**BN/68/26/DOC**

**Address:** Barnham Court Church Lane Barnham PO22 0BP

**Proposal:** Approval of details reserved by condition imposed under BN/128/25/L relating to condition 11-method for plaster removal and plaster specifications.

DRAWING TITLE:
**Proposed
Cond. 11 - Heritage Plasterwork**

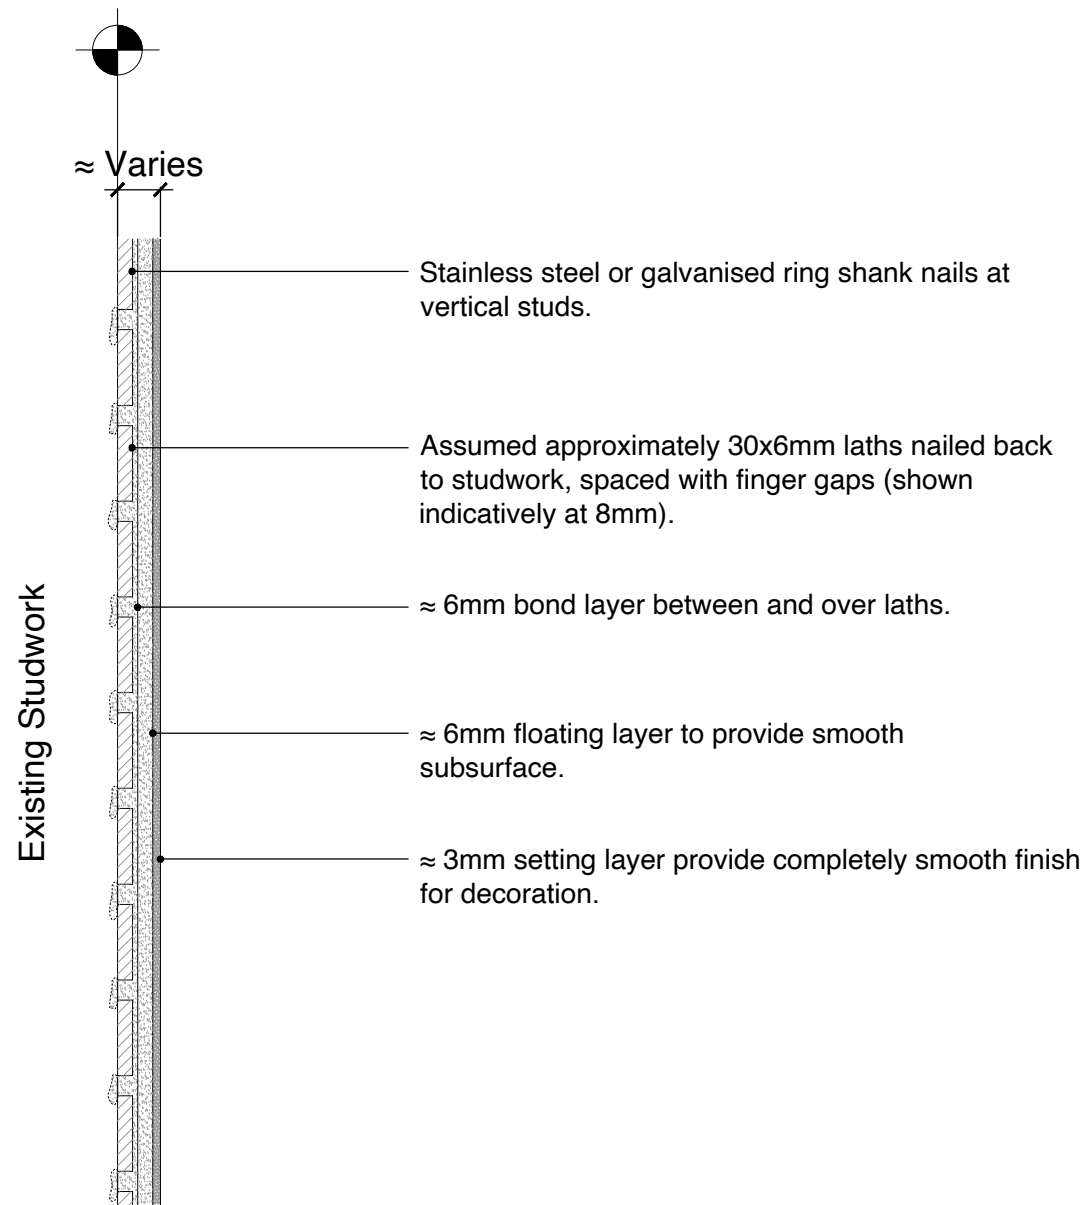
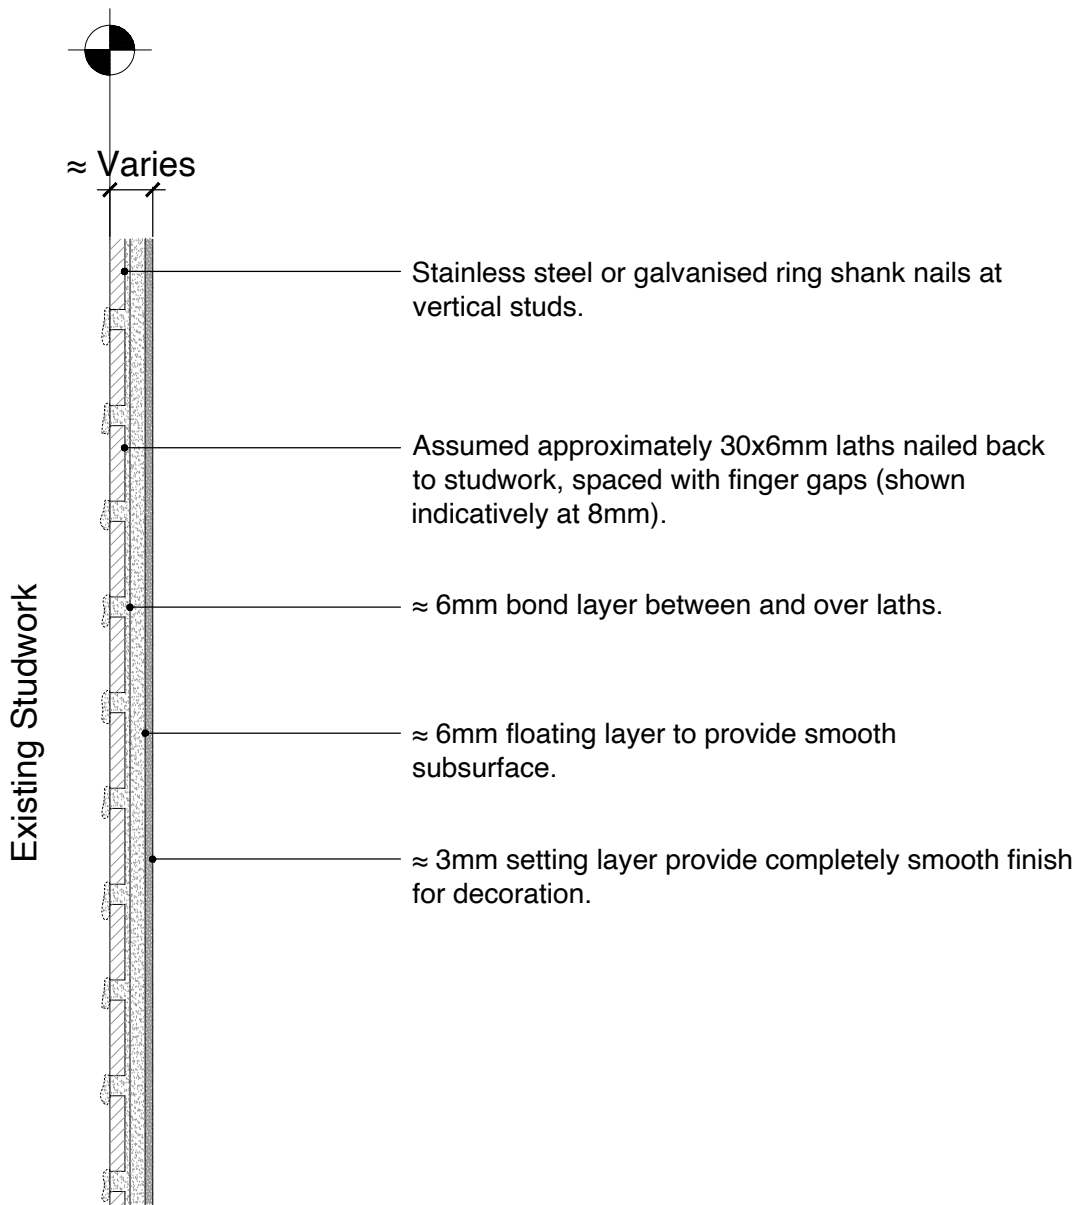
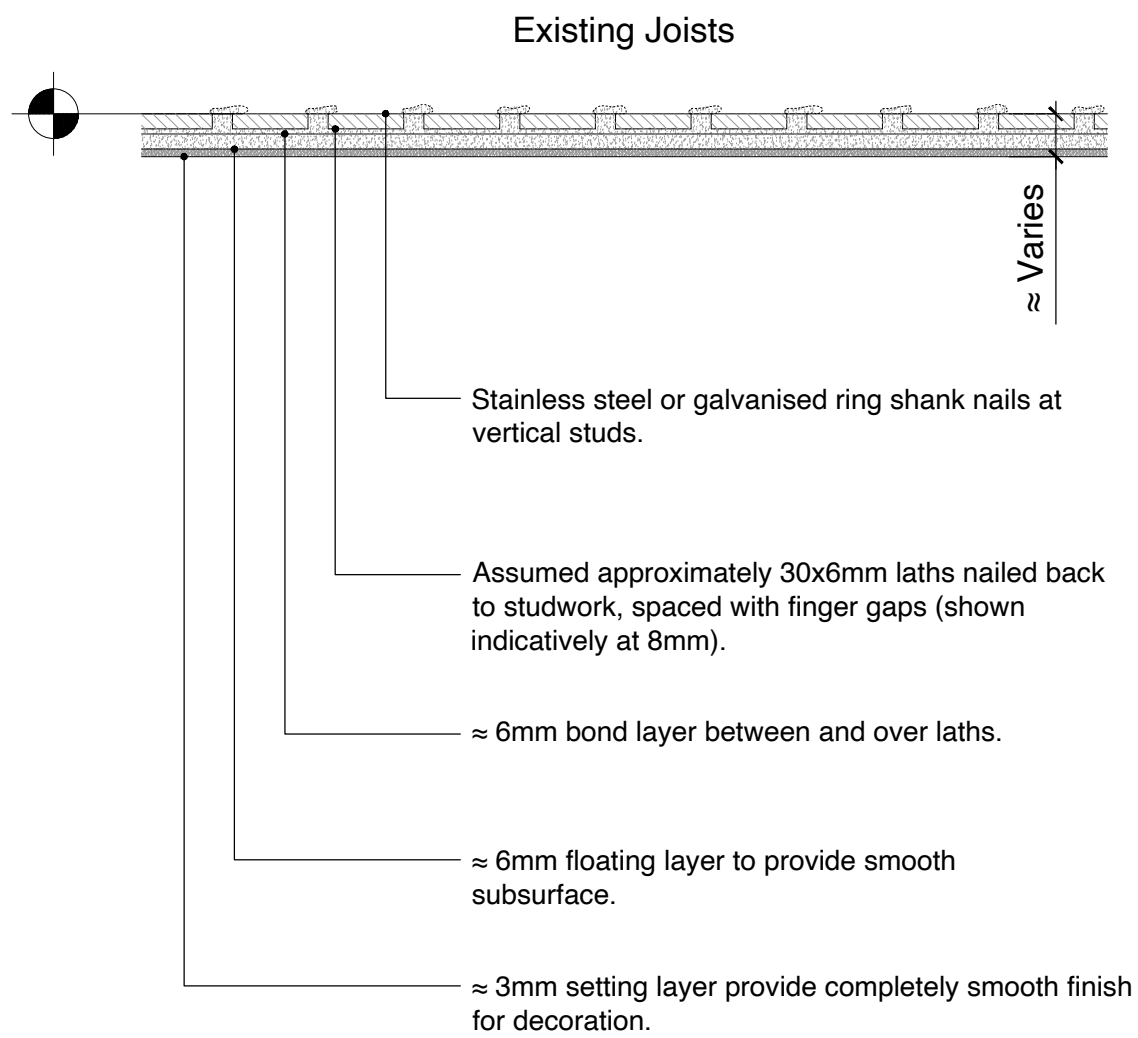
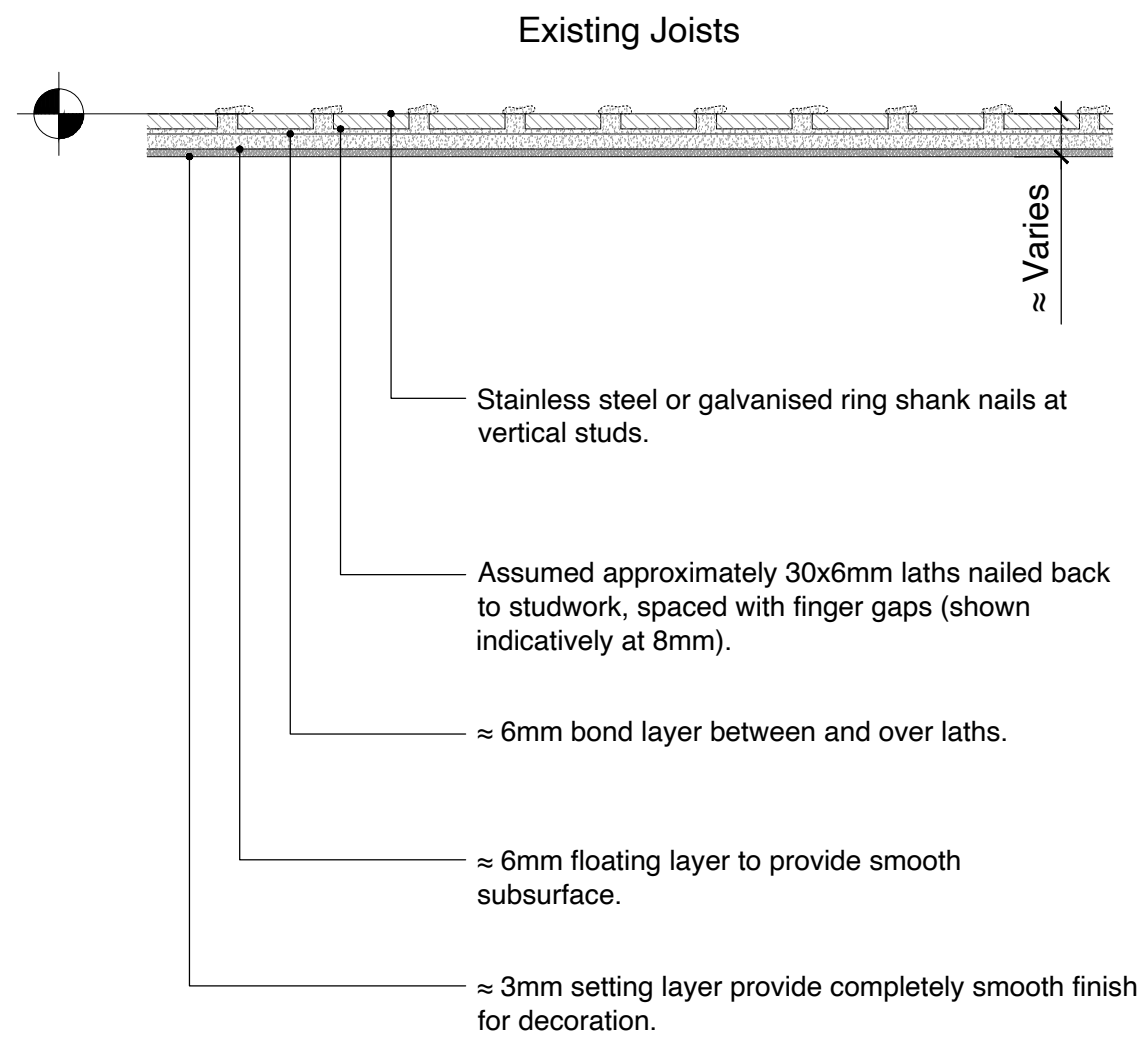
Whilst the proposed methodology appears acceptable, I have been unable to locate details of the plaster specification. Please could you confirm whether this has been provided. It is assumed that the plaster would be specified to match the original, potentially informed by an assessment of its composition.
